WELWYN HATFIELD COUNCIL – DEVELOPMENT CONTROL
DELEGATED REPORT

APPLICATION No:	N6/2011/2683/AD
------------------------	------------------------

This application seeks retrospective advertisement consent for the installation of a fascia sign which is along the frontage of Howardsgate and has a width of 14.5m. It has green and red lettering and symbols on a white background. A projecting sign is located on the corner of the building which is illuminated and projects from the building by 0.9m.

DRAWING TITLE WELWYN GARDEN CITY POST OFFICE 17 HOWARDSGATE WELWYN GARDEN CITY HERTS AL8 6AL		
SCALE 1:100@A3	DRAWING No KL- 060610 - SF	DATE 06/05/11
DRAWN kevin.lear@costcutter.com	REVISIONS SF	
 HARVEST MILLS, COMMON ROAD, DUNNINGTON, YORK. YO19 5RY TELEPHONE: 01904 488663 FAX 01904 489828

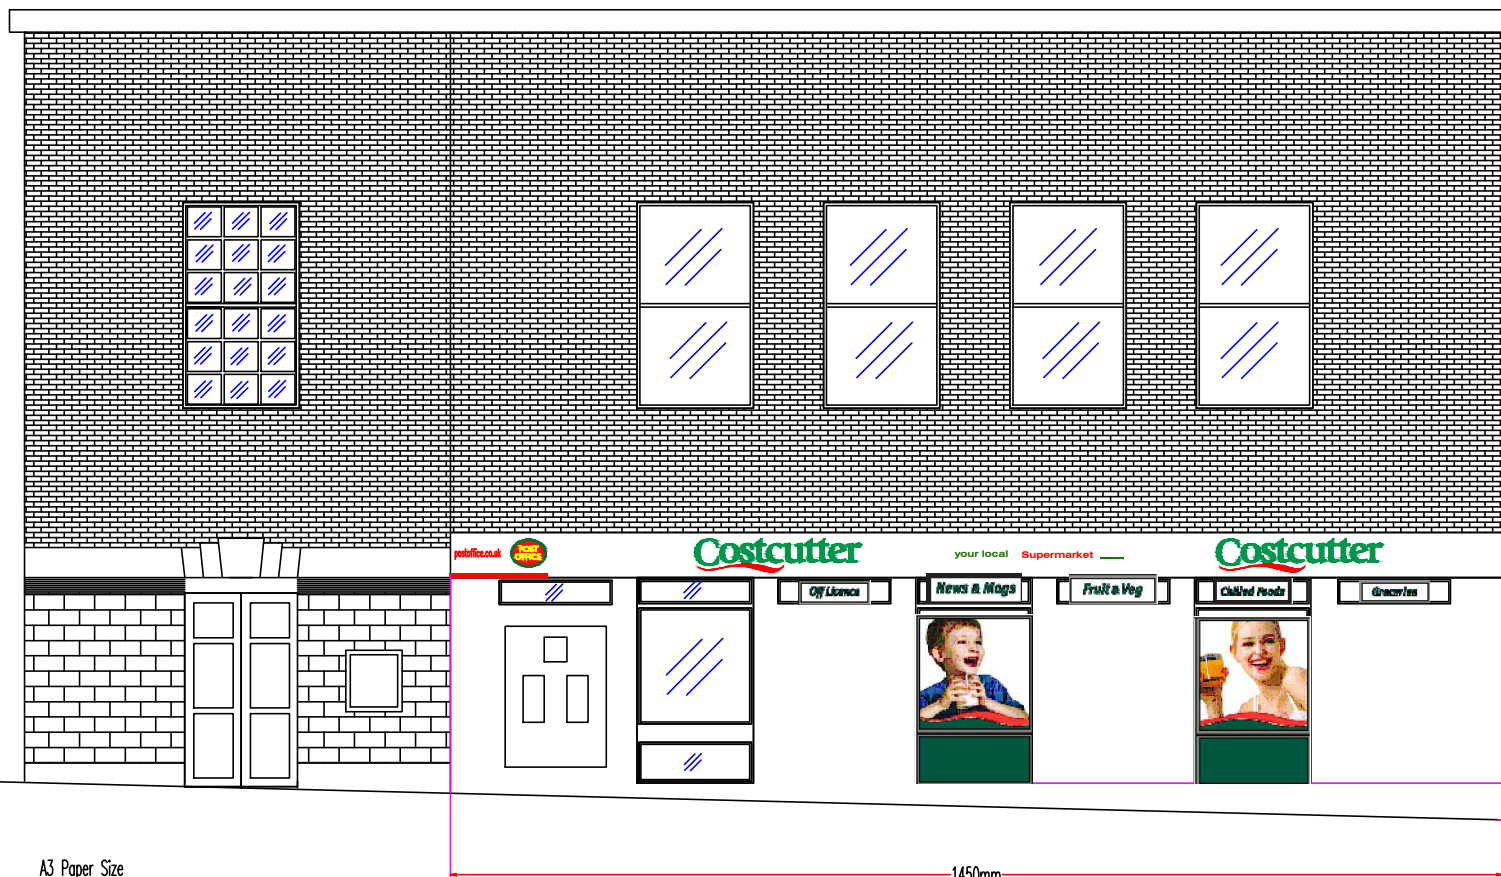
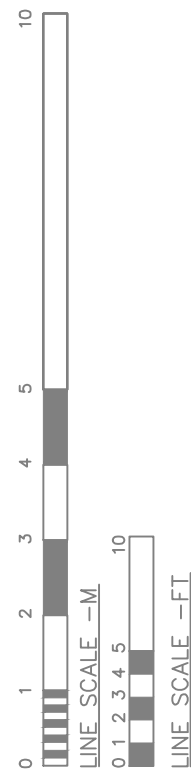
The proposed fascia sign on the Howardsgate elevation is above the stonework of the building at the ground floor. It is sited along the length of this building and stops where the adjoining part of the building juts out slightly which relate to the design of these buildings along Howardsgate. This building has no fascia and has a stone band running along its entire width above shop front level. This building is individually designed where the building is predominantly finished in facing brickwork and stonework with stone banding dividing the stone work and the brick. The building exhibits strong detailing in its overall design. Whilst the design of the sign is simple, with a flat background and the legend 'cost cutter' placed along the building, it is a standardised sign which has not been sensitively positioned on the building and does not enhance or maintain the character of Welwyn Garden City Conservation Area. The proposed fascia board runs across the entire length of the stone banding on the Howardsgate elevation and obscures all of this from view, which is one of the main architectural qualities of this building. This standardised approach is considered inappropriate because it introduces a size and style of advert that has an unacceptable impact on the visual amenity and masks an original architectural detail of the building. It is therefore considered that the sign has paid inadequate attention to the character and appearance of its surroundings, appearing as a detrimental addition to the street scene which spoils the conservation area.

Previously the post office had signage located above this band but they were individual signage and still allowed for the architectural detailing to be seen which was approved consent under application reference N6/2997/0960/AD. Subsequently the proposed fascia signage, displayed in the current size, siting and design detract from the special architectural and historic character of this building which is sited within the Welwyn Garden City Conservation Area which also has a detrimental impact to the visual amenities and character of the visual amenity of the area. The proposal would therefore fail to comply with the provisions of PPS5, PPG19 and District Plan policy GBSP2, D2 and D1.

With regard to the projecting box sign this would be illuminated and would be 0.9m x 0.6m. As with the fascia sign, this is considered to be of simple design and modest

in size where there are other projecting signs similar in size within the locality. However, the proposed sign, like the fascia sign, is standardised and consists of a bulky addition to the side which is located on the corner of the building with Wigmores North and Howardsgate where it would be unduly prominent and would have an unacceptable impact on visual amenity. This sign would be illuminated which would exacerbate its prominence and cause the sign to be even more prominent and appear as a rather uncompromising feature. Therefore, it is considered that the projecting sign in its present location, would also detract from the appearance and character of the conservation area. Whilst appreciated there are other projecting signs within the locality, these signs are much thinner and have more regard to the conservation area they are sited within. The existing projecting post office sign located on the elevation facing towards Wigmores North, whilst similar to the proposed sign, is smaller. Therefore whilst it was approved in 1998, every case is considered on its own merits and this is not considered to result in no objections being raised.

1. It is considered that the size, siting and design of the proposed fascia signage is out of keeping with the locality and takes no consideration to the architectural qualities of the application building. In addition, the proposed projecting sign would be unduly prominent within the street scene of Howardsgate detracting from the Central Welwyn Garden City Conservation Area. The proposal is thereby detrimental to the visual amenities and character of the area and would thereby fail to make a positive contribution to the character and local distinctiveness of Welwyn Garden City Conservation Area and would be against the presumption in favour of the conservation area. The proposal would therefore be contrary to PPS5, PPG19 and Policies D1, D2 and GBSP2 of the Welwyn Hatfield District Plan and Welwyn Hatfield District Plan Supplementary Design Guidance 2005, Section 6 (Statement of Council Policy), PPG19 and Advertisement Regulations in that it is detrimental to visual amenity.
